Our Case Number: ABP-317560-23

Re: Proposed windfarm development including 13 no. wind turbines in Bunnyconnellan, Co. Mayo and hydrogen plant in Castleconnor, Co. Sligo.
Carrowleagh, Bunnyconnellan, Co. Mayo and Curraun, Castleconnor, Co. Sligo.

Ár dTag | Our Ref.
TII23-123905

Re. **Strategic Infrastructure Development – Proposed windfarm development including 13 no. wind turbines in Bunnyconnellan, Co. Mayo & hydrogen plant in Castleconnor, Co. Sligo (ABP Case ref. PA16.317560)**

Figure NTS-5: Proposed Turbine Delivery Haul Routes

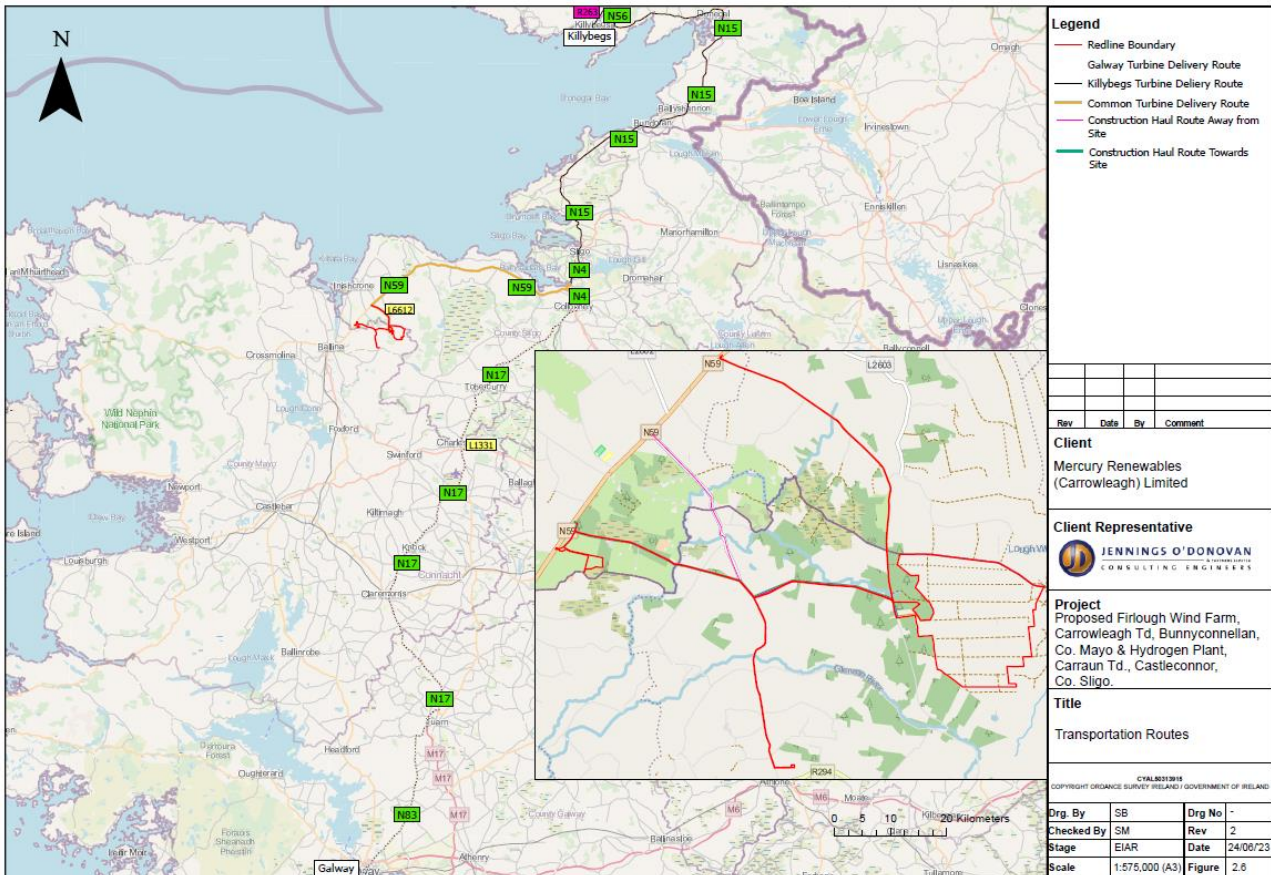
In relation to the proposed Turbine Component delivery to site, Section 15.5.4 of the EIAR outlines the Turbine Component Haul Route to site from the ports of entry at Killybegs and Galway Port. Appendix 15.1 (A & B) contain turbine delivery haul route assessments and outline proposed temporary works impacting the national road network.

The national road network is managed by a combination of PPP Concessions, Motorway Maintenance and Renewal Contracts (MMaRC) and local road authorities. The applicant/developer should consult with all PPP Companies, MMaRC Contractors and road authorities over which the haul routes traverse to ascertain any operational requirements such as delivery timetabling, etc. and to ensure that the strategic function of the national road network is maintained.

Any proposed works to the national road network to facilitate turbine component delivery to site shall comply with TII Publications and shall be subject to Road Safety Audit as appropriate. Works should ensure the ongoing safety for all road users and prior to any development necessary licenses, approvals, permits or agreements with PPP Concessions, Motorway Maintenance and Renewal Contracts (MMaRC) Companies and local road authorities, as necessary, shall be in place.

Any damage caused to the pavement of the existing national road due to the turning movement of abnormal 'length' loads (eg. tearing of the surface course) shall be rectified in accordance with TII Pavement Standards and details in this regard shall be agreed with the Road Authority prior to the commencement of any development on site.

The Authority considers that it is critical a full assessment by the applicant/developer of all structures on the national road network along the haul route should be undertaken, where relevant, and all road authorities along the haul routes should confirm their acceptance of proposals by the applicant.

The Authority has reviewed the EIAR documentation referred and is concerned that no technical load assessment of structures appears to have been undertaken in support of this proposed application. However, it is acknowledged that abnormal weight loads may not be a feature of the proposed development.

The Authority considers that it is critical a full assessment by the applicant/developer of all structures on the national road network along the haul route should be undertaken, where relevant, to confirm that all structures can accommodate the proposed loading associated with the delivery of turbine and associated development
